3rd July 2023

RE: OBJECTION TO ERECTION OF DETACHED BUILDING TO CREATE DWELLING FORMING ANNEX ACCOMMODATION ASSOCIATED WITH 10 FULNECK CLOSE, FIXBY, HUDDERSFIELD, HD2 2LJ

LPA REF: 2023/91287

PROJECT TITLE
10 Fulneck Close, Fixby
Proposed Garden Room
DRAWING TITLE
Proposed plans and elevations
DRAWING NO.
TNB - XX - XX - XX.XX - D - A - 0002_ (S0 - P1)

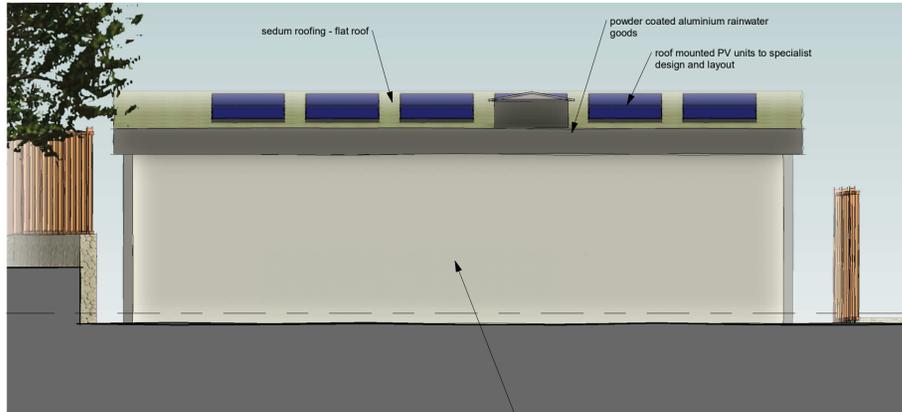
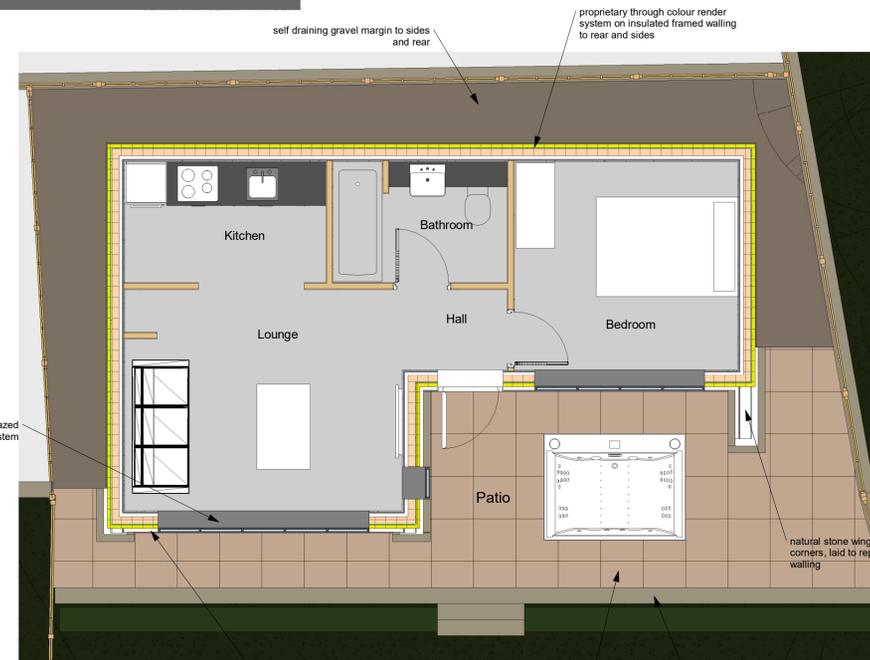
Although the proposed building is single storey, its height would still project above the existing boundary fence. Furthermore, the overall scale of the building and its location directly adjacent to the shared boundary, would result in an intrusive and overbearing impact on our clients' house and garden, reducing their current outlook and enjoyment of their property.

Floor Plan

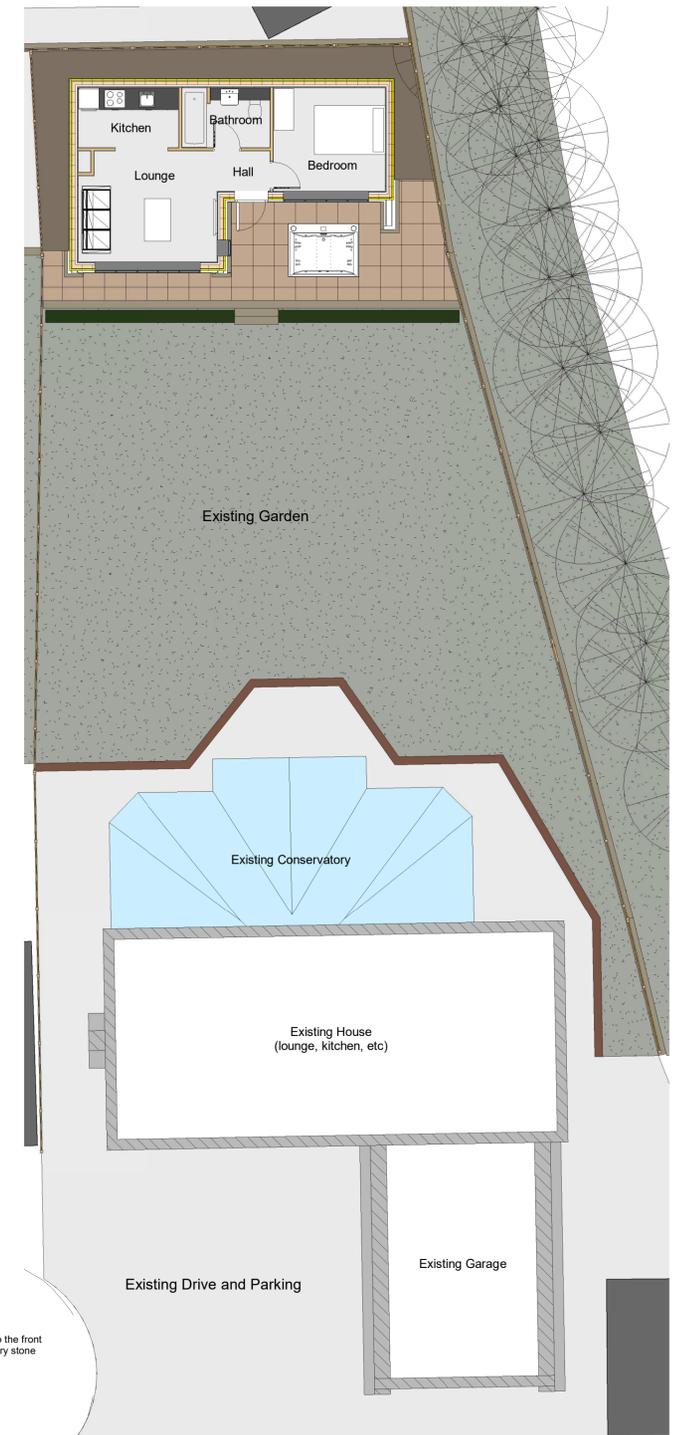
Our client's concern is that if it is indeed the applicant's intention that the family member still uses the main dwelling house for cooking, dining and bathing, why do the plans include a fully functioning bathroom with a bath, and a fully functioning kitchen with a sink, cooker etc. Such facilities would arguably constitute a fully self-contained unit providing all of the facilities necessary for independent day-to-day living, thus potentially representing a new planning unit.

Our client contends that a simple W.C and a kitchenette should be adequate if the family member is still going to continue to use the facilities in the main dwelling. Clarifying this through the plans would also avoid any objective doubt concerning potential future uses of the proposed outbuilding in future (i.e. use as an independent dwelling house).
